**From:** Katie Herr [REDACTED]  
**Sent:** 28 January 2022 12:09  
**To:** David Easton <[David.Easton@arun.gov.uk](mailto:David.Easton@arun.gov.uk)>  
**Subject:** Full Objection A/256/21/RES

## Angmering Parish Council

## A/256/21/RES - Comments from Angmering Parish Council.

Front Elevation

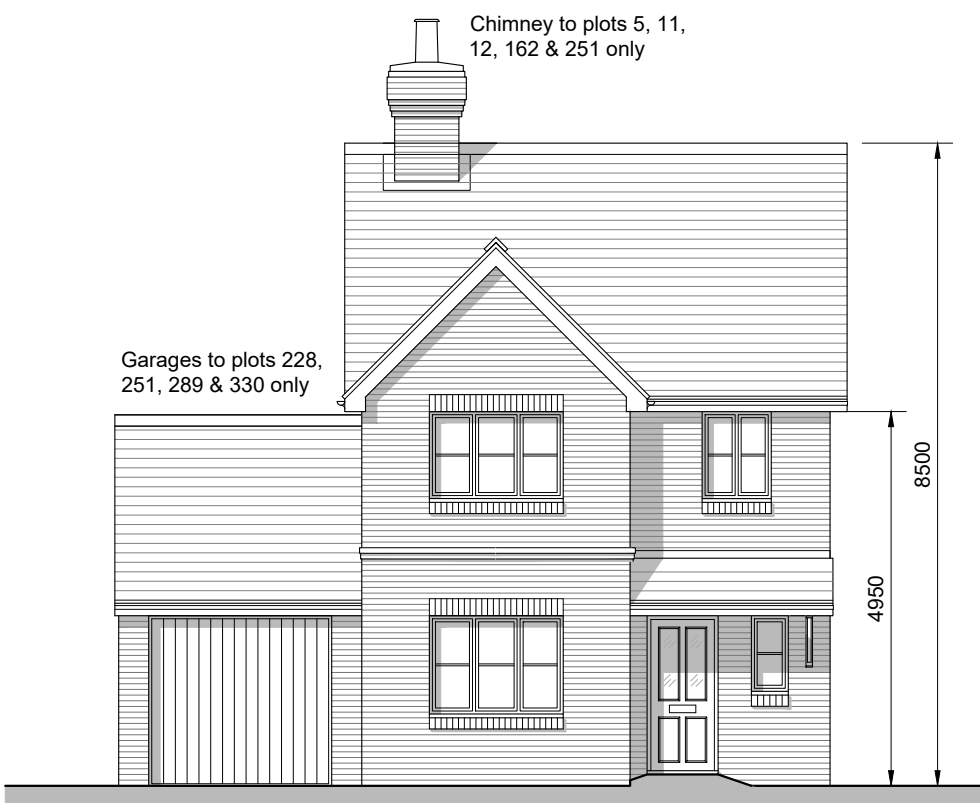
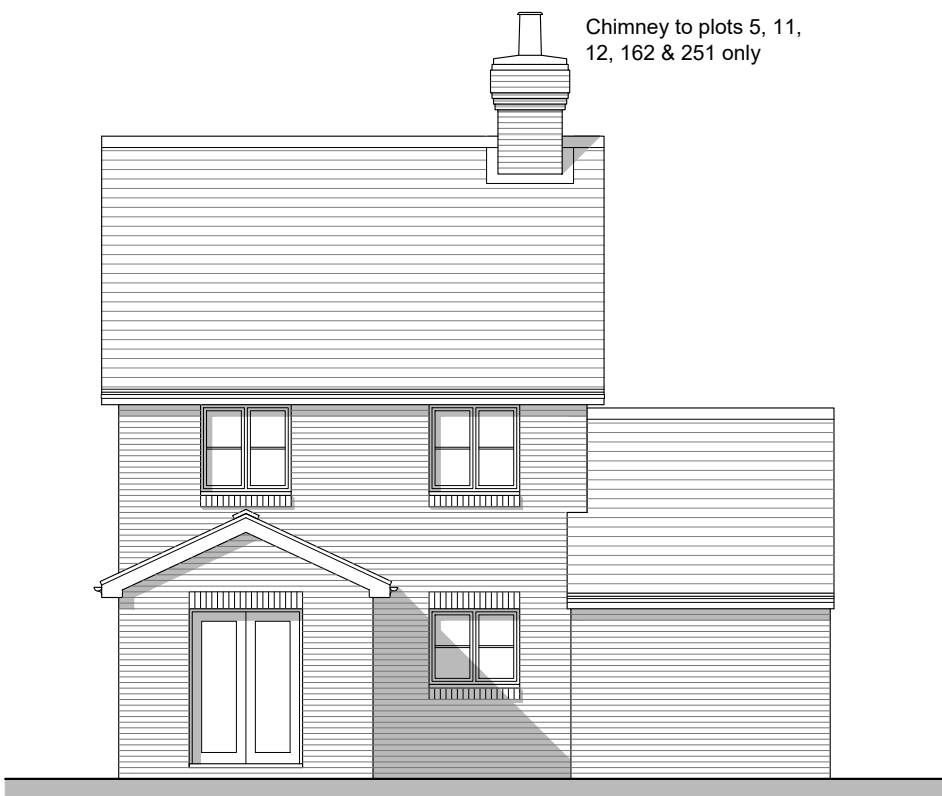
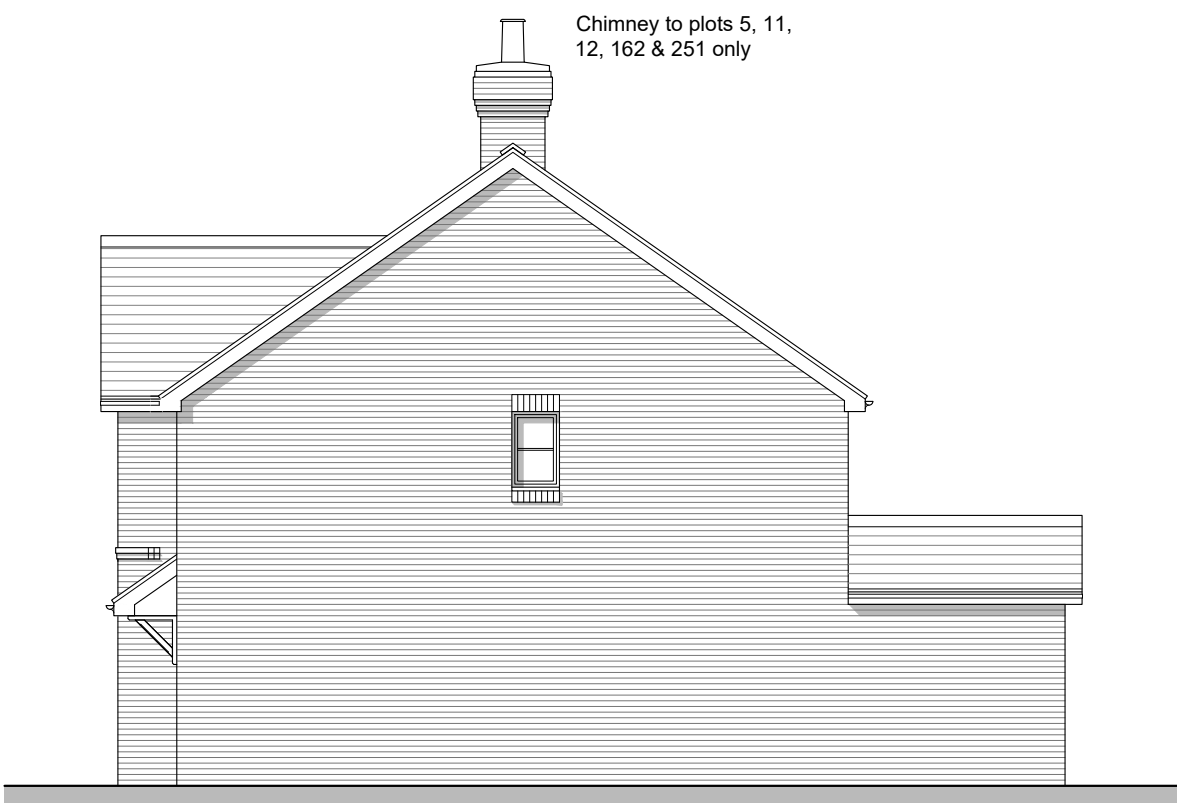
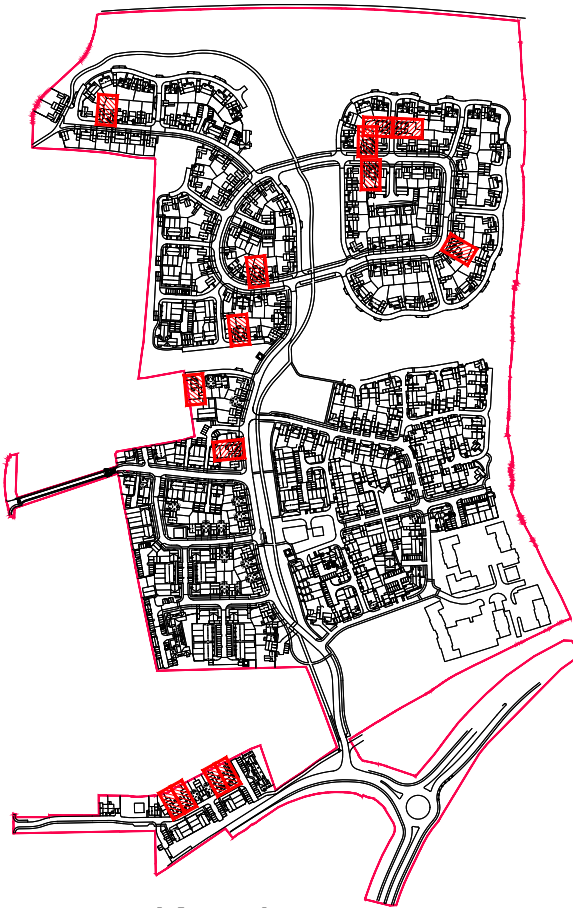
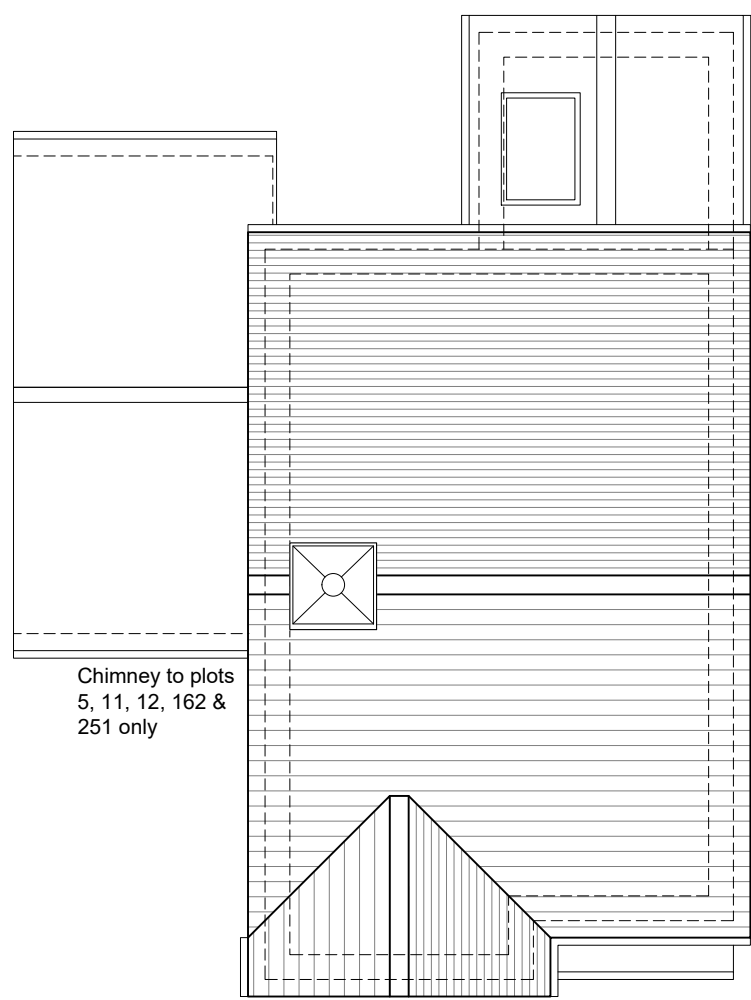
In contrast the Reserved Matters application includes apartment blocks that are fully 3storeys high as shown below.

Building 7 - Front Elevation

These buildings would be over 11.6 metres high and the proposed second floor space is as large as the two storeys below demonstrating that this is a true 3 storey building rather than a 2.5 storey. This compares with the 2.5 storey houses which are 9.9 metres high and the rooms wholly within the roof space. As a result the floorplan for the top storey is half the size of the lower two storeys.

The proposed apartment blocks do not comply with the parameters plan (either that approved under A/40/18/OUT or proposed under A/248/21/PL) because they are fully 3 storey rather than 2.5 storey. This is demonstrated by their height (11.6 metres compared to 9.9 metres for the 2.5 storey houses) and the fact that the floor plans for the top storey are the same size as that for the lower two storeys. The height and bulk of these buildings would be detrimental to the character of the site and the surrounding area contrary to Policy HD5 (Built Form) of the Neighbourhood Plan which specifically states that "No new buildings will be permitted over 2.5 storeys (based on the typical heights of existing buildings in the immediate surrounding area) unless it can be demonstrated that the proposal would be in keeping with its surroundings".

3. Bus and emergency vehicle access from Dappers Lane (iTransport)

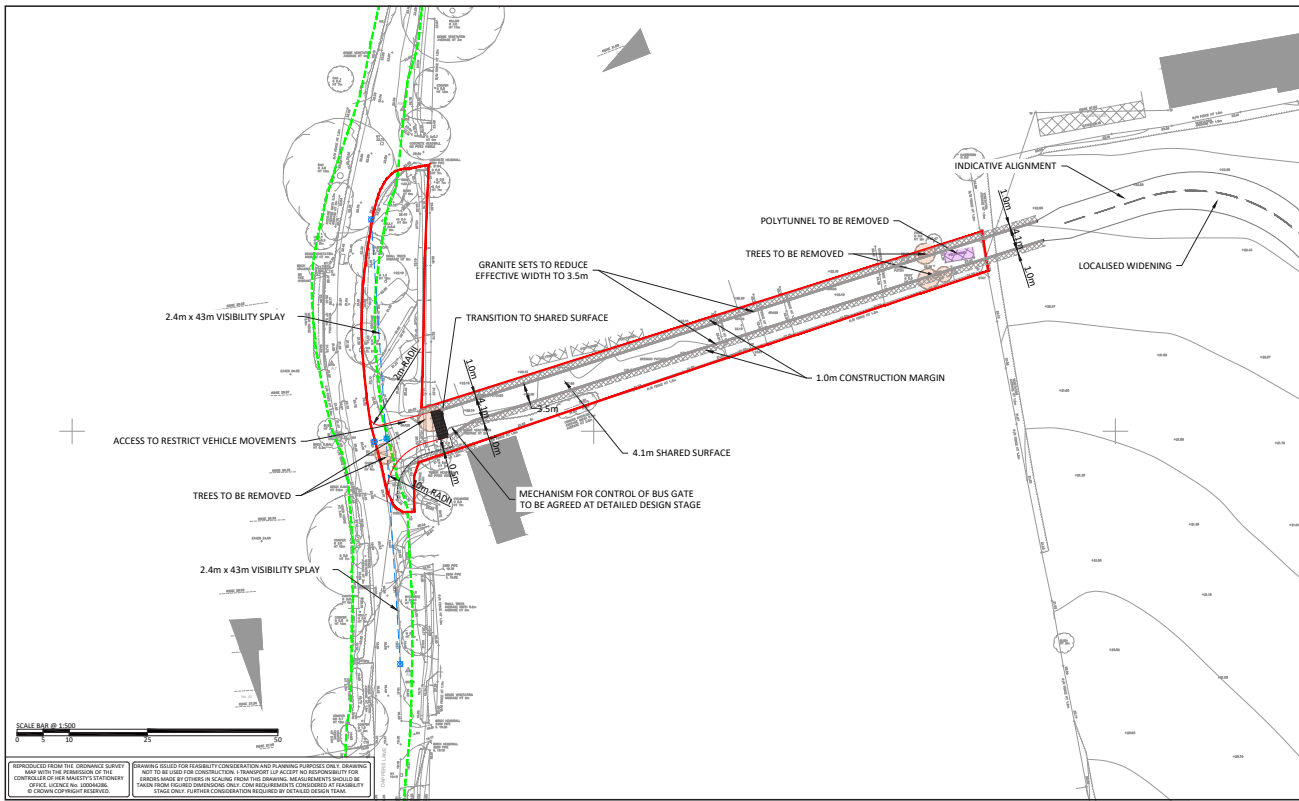
We are receiving conflicting reports on the effectiveness of the ANPR Camera proposed in the bus and emergency vehicle link road access from Dappers Lane.

Unless it can be guaranteed that legal action would automatically follow unauthorised vehicle access or exit, a gate (as originally proposed) should be installed

Revised building heights parameter plan ►

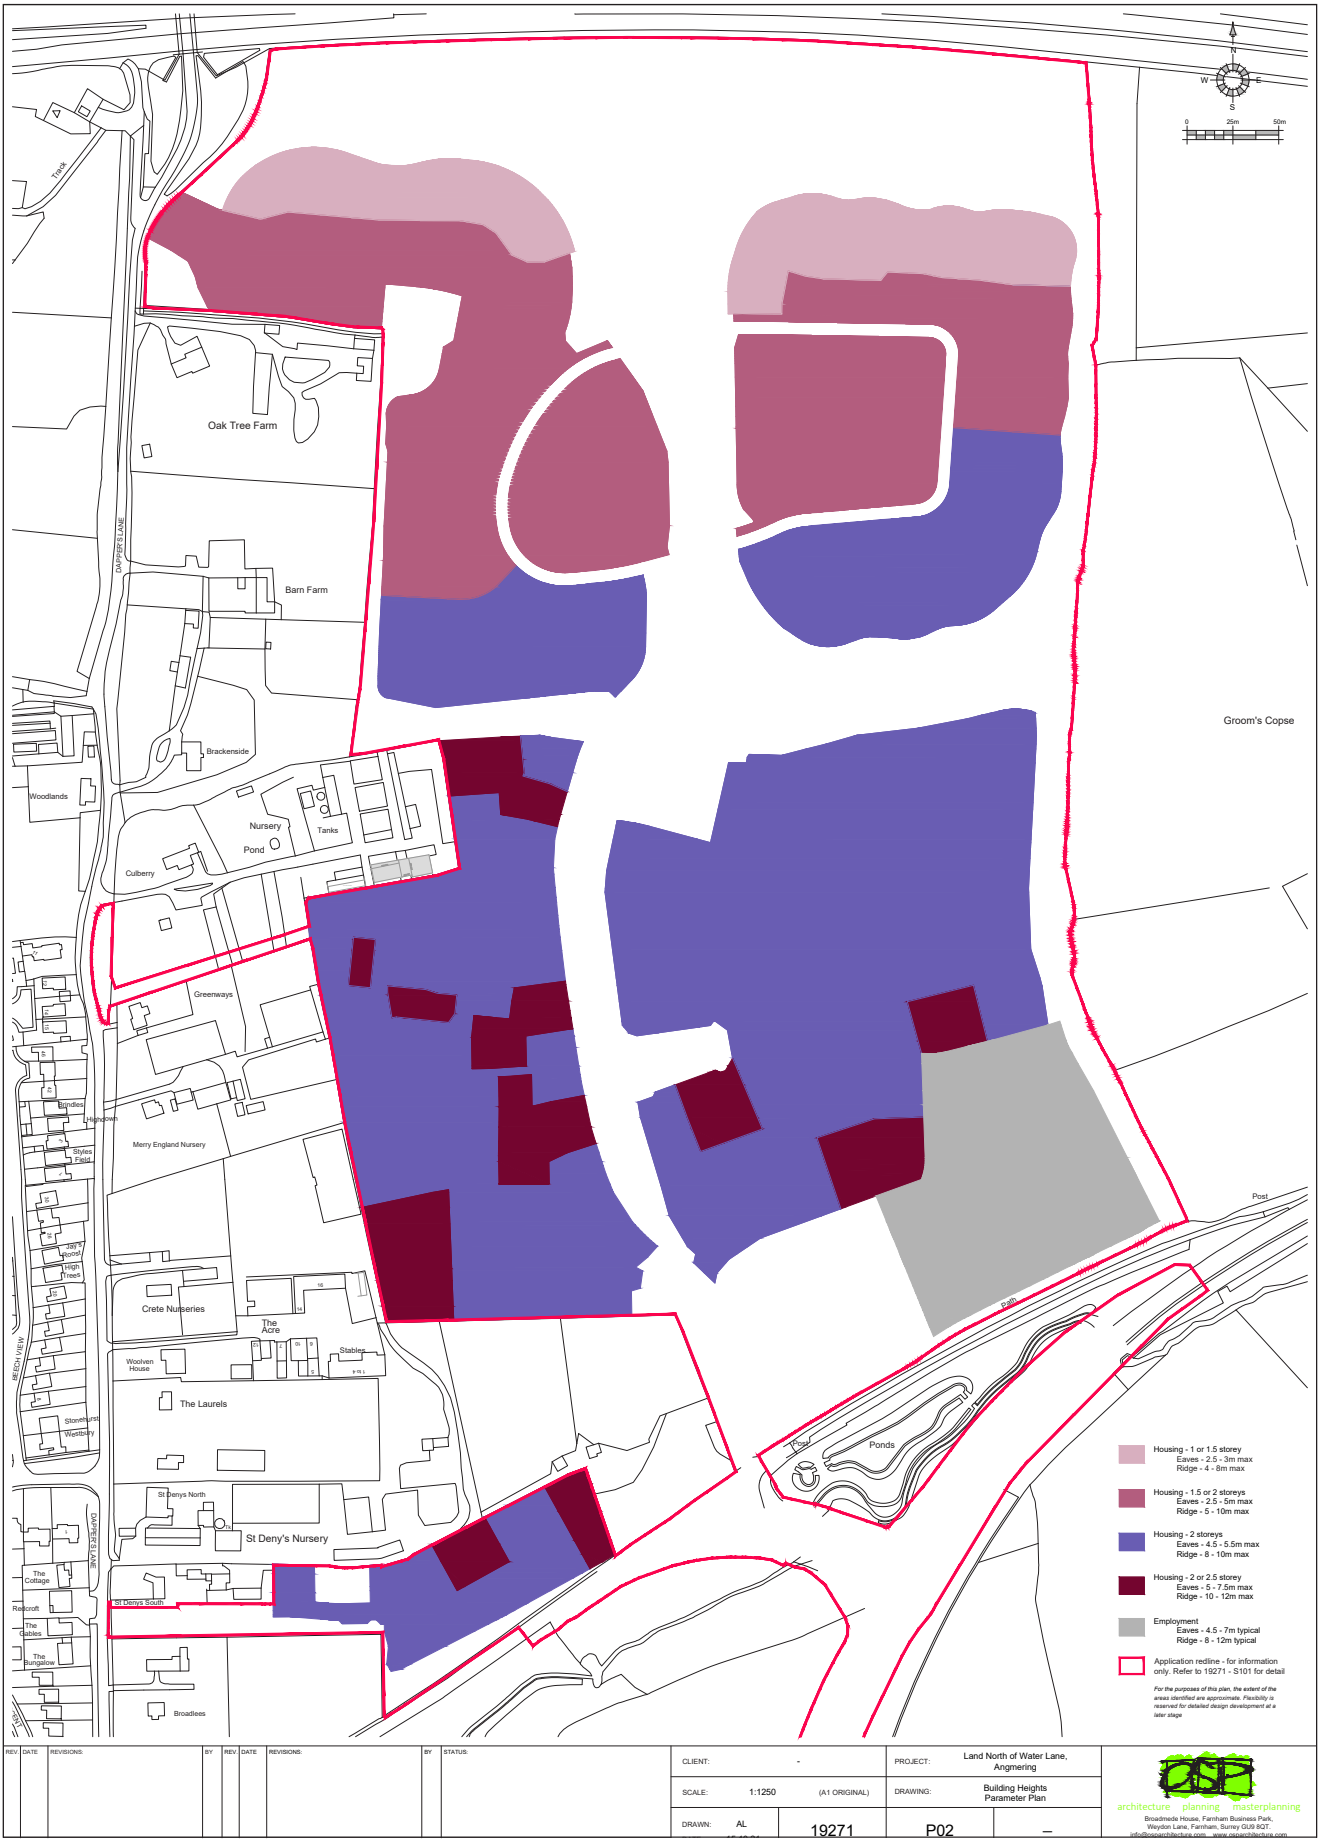
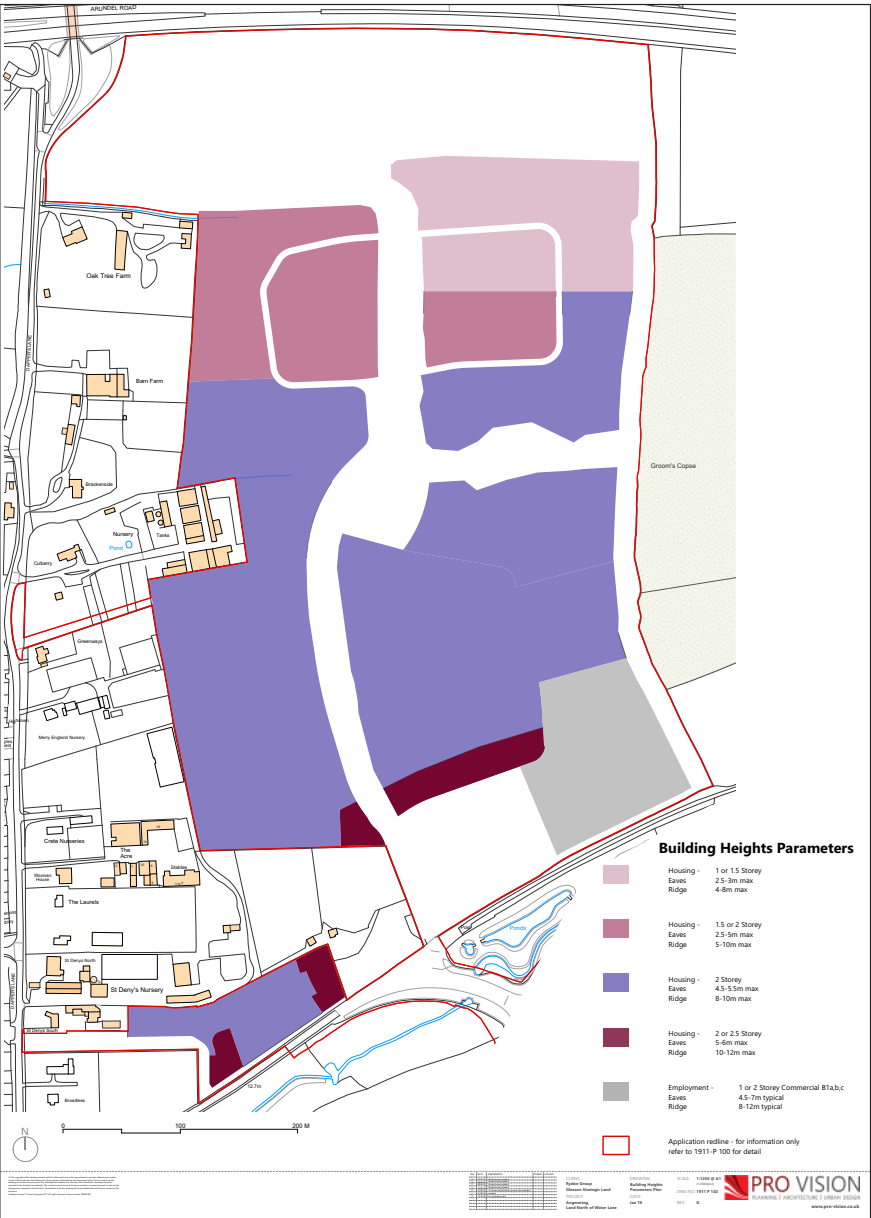
The detailed Reserved Matters plans proposed do not comply with even the amended parameters plan. Whilst the proposed amendments to the parameters plan change the distribution of the highest dwellings on the site, these continued to be described as '2- 2.5' storey – the latter term generally being used to describe buildings where there are two full storeys but also rooms above the second storey within the roof space.
